Hunter Water Corporation
ABN 46 228 513 446

Our Ref: HW2016-492

SSD 7332 EIS – PROPOSED HARD ROCK QUARRY – BARLEIGH RANCH WAY, EAGLETON – ADDENDUM TO SUBMISSION

Project No:	Eagleton Quarry	Dwg Title:	Proposed Rock Quarry
Suburb:	Eagleton	Sheet Title:	Year 1
Street:	13 Barleigh Ranch Way	Number of Sheets:	1
Lot & DP:	Lot 2 DP1108702	Sheet Number:	1

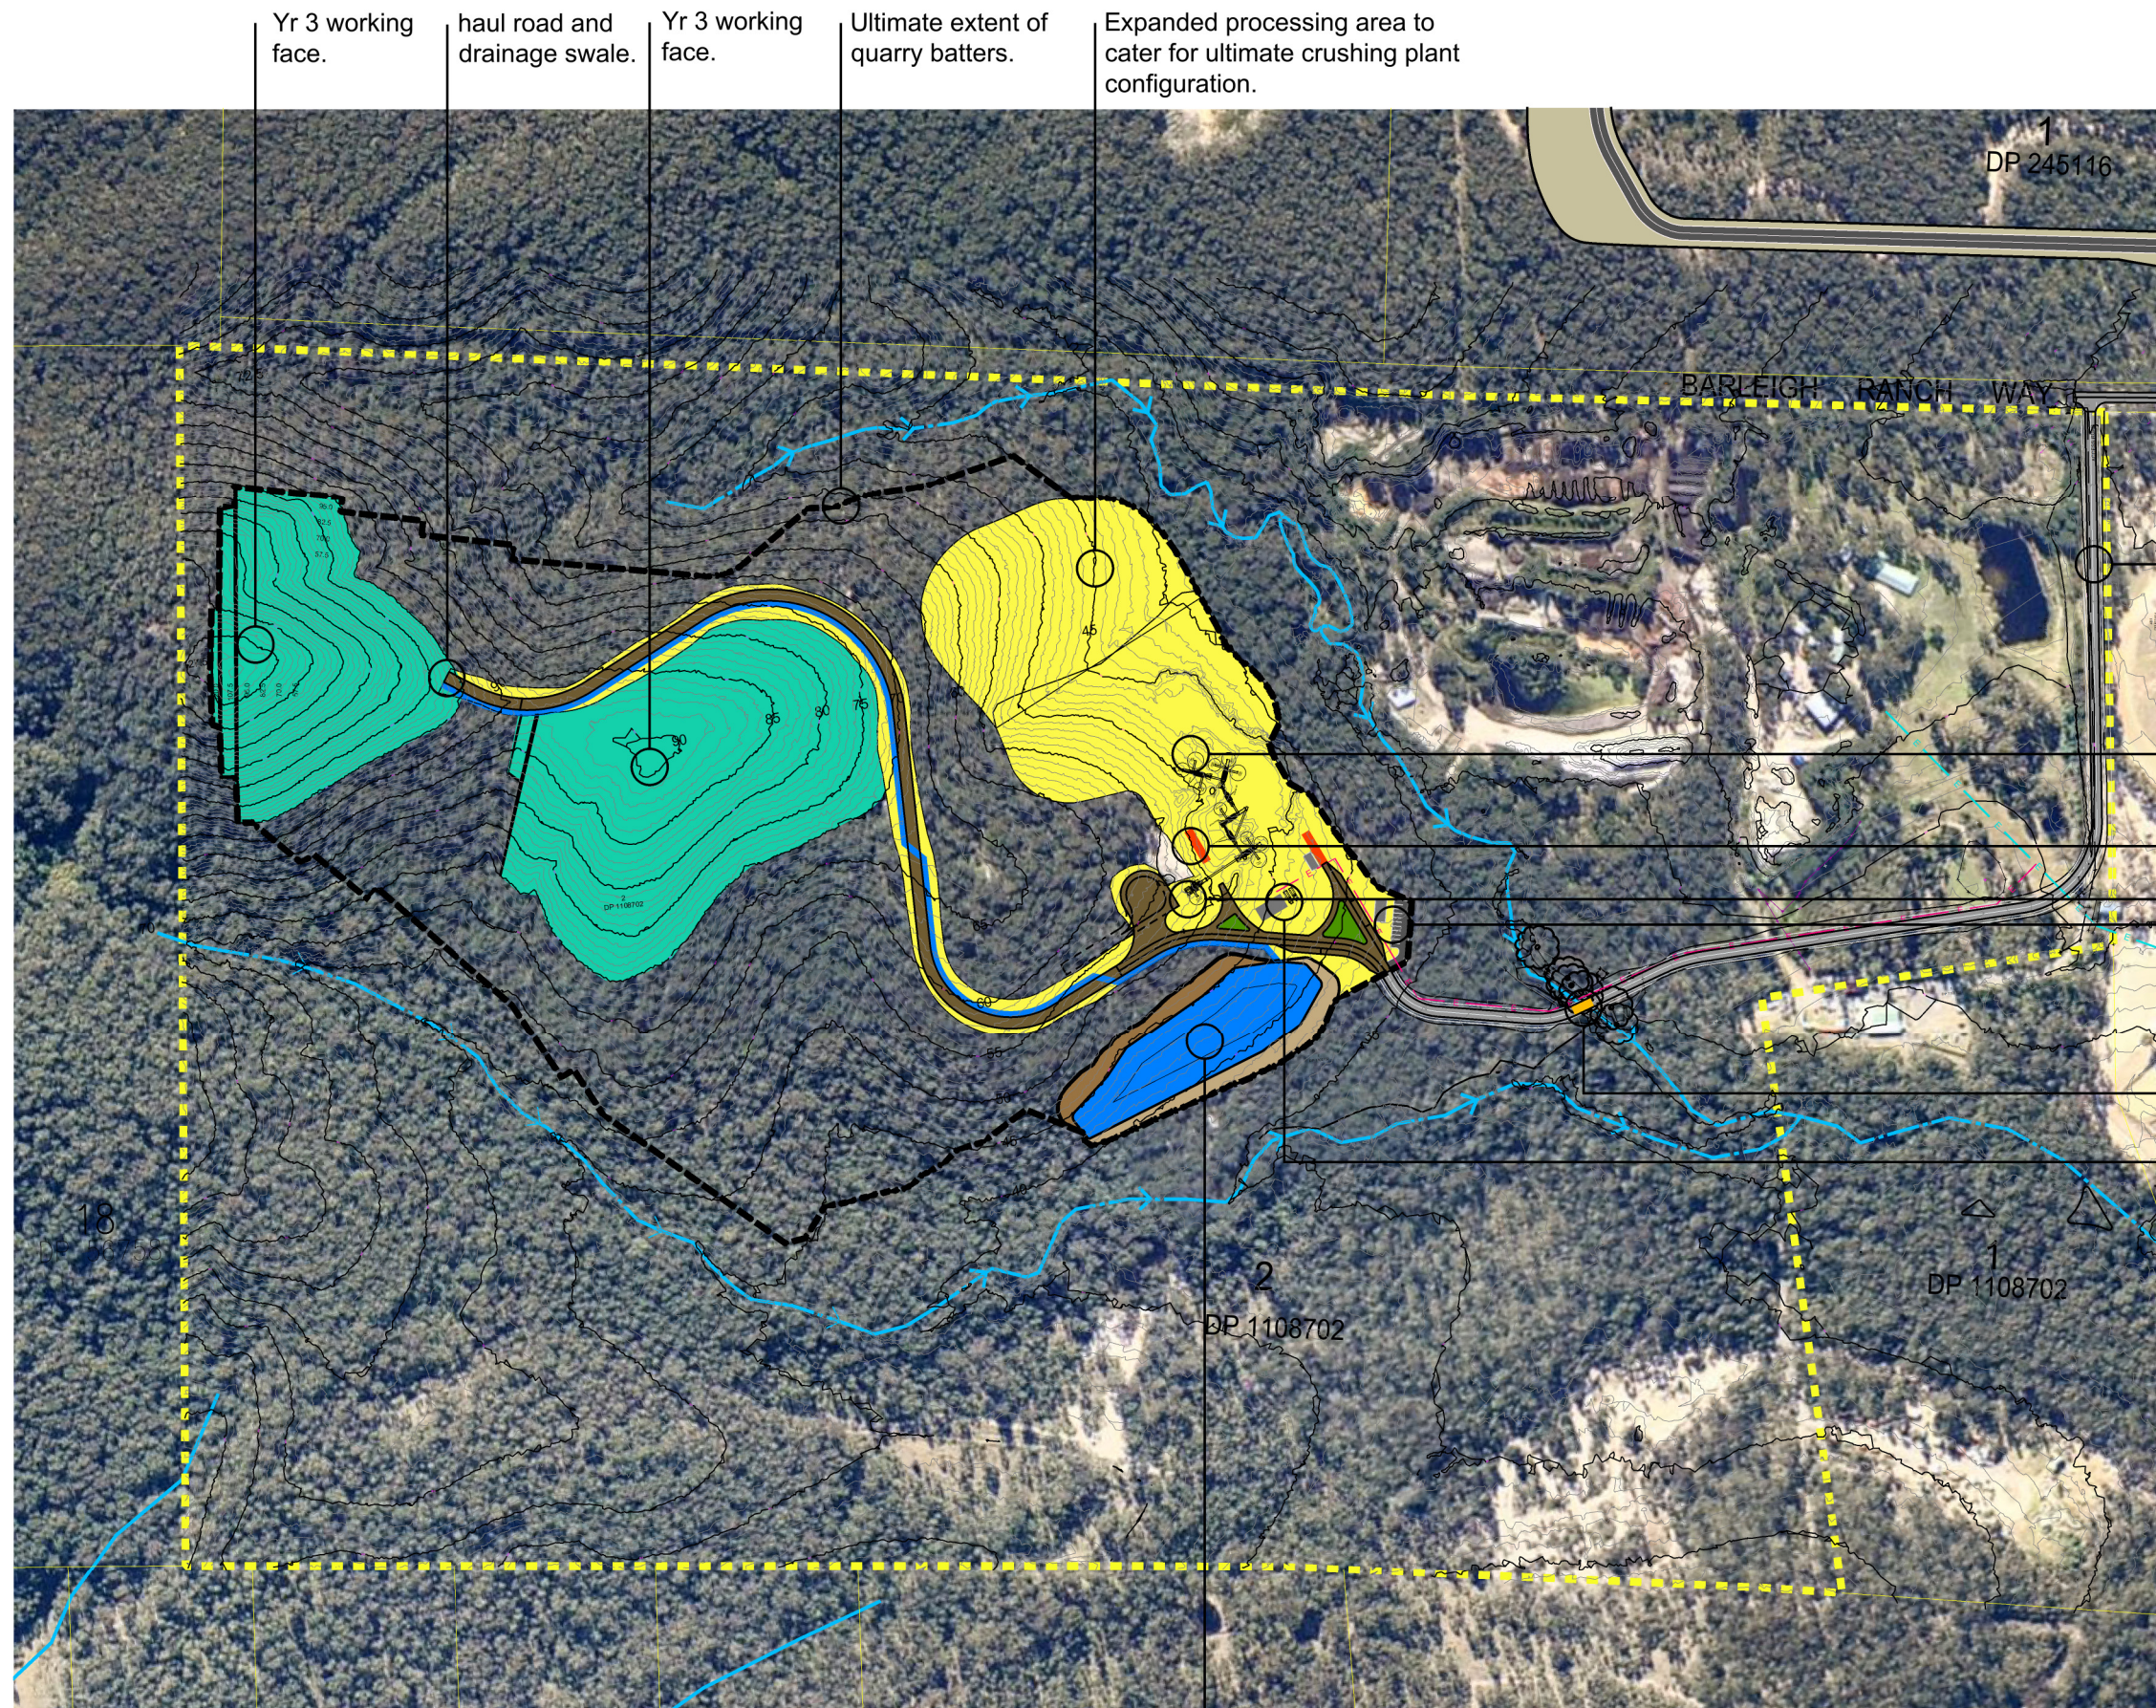
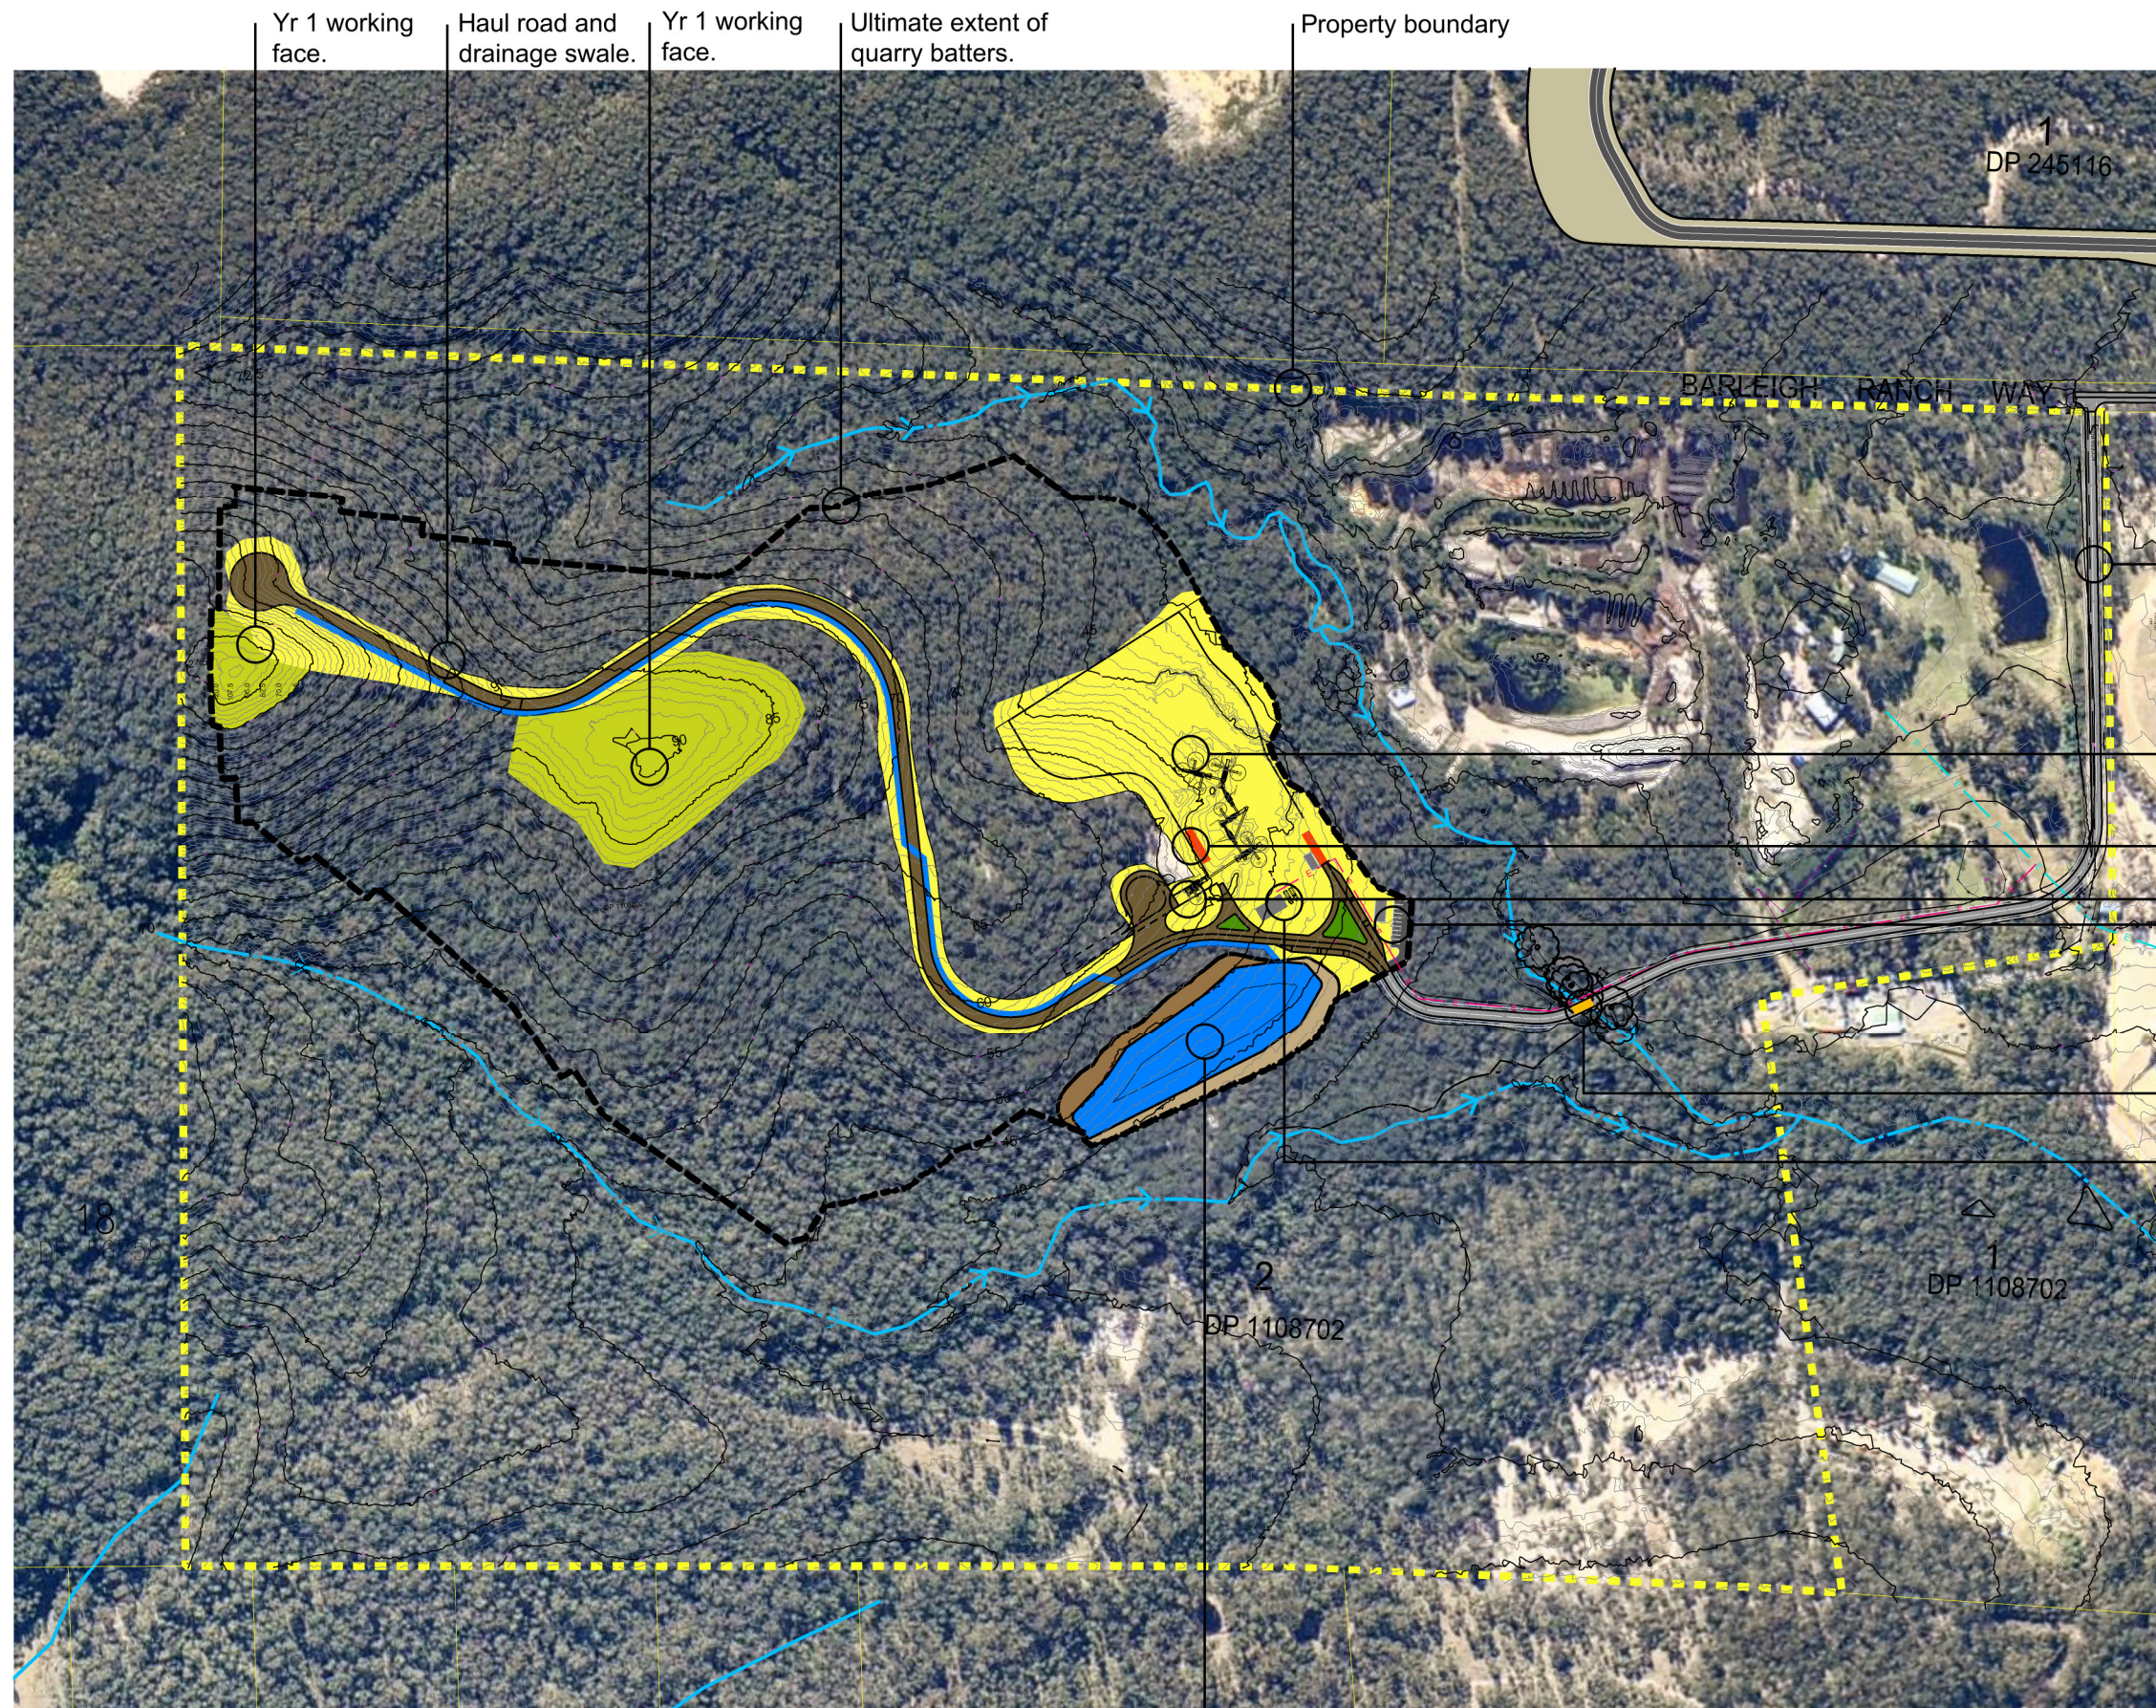
- Dams 1 and 2 will capture significant volumes of sediment over the life of the quarry. This volume will be related to the effectiveness of catch drains, check dams, sediment traps and the upslope bunded areas, which in turn will depend on the levels of maintenance undertaken throughout the quarry lifecycle. Typically, many of these measures are poorly maintained and their functions not well understood by site operators, leading to significant volumes of sediment being washed into sediment basins, meaning these structures become the only effective barrier prior to discharge into an adjacent waterway. Inadequate maintenance is considered to be a key risk to water quality for this development.

- The low flow pipes proposed to be incorporated into the bunds that detain stormwater would appear to make them permeable and therefore ineffective for controlling more frequent runoff events.
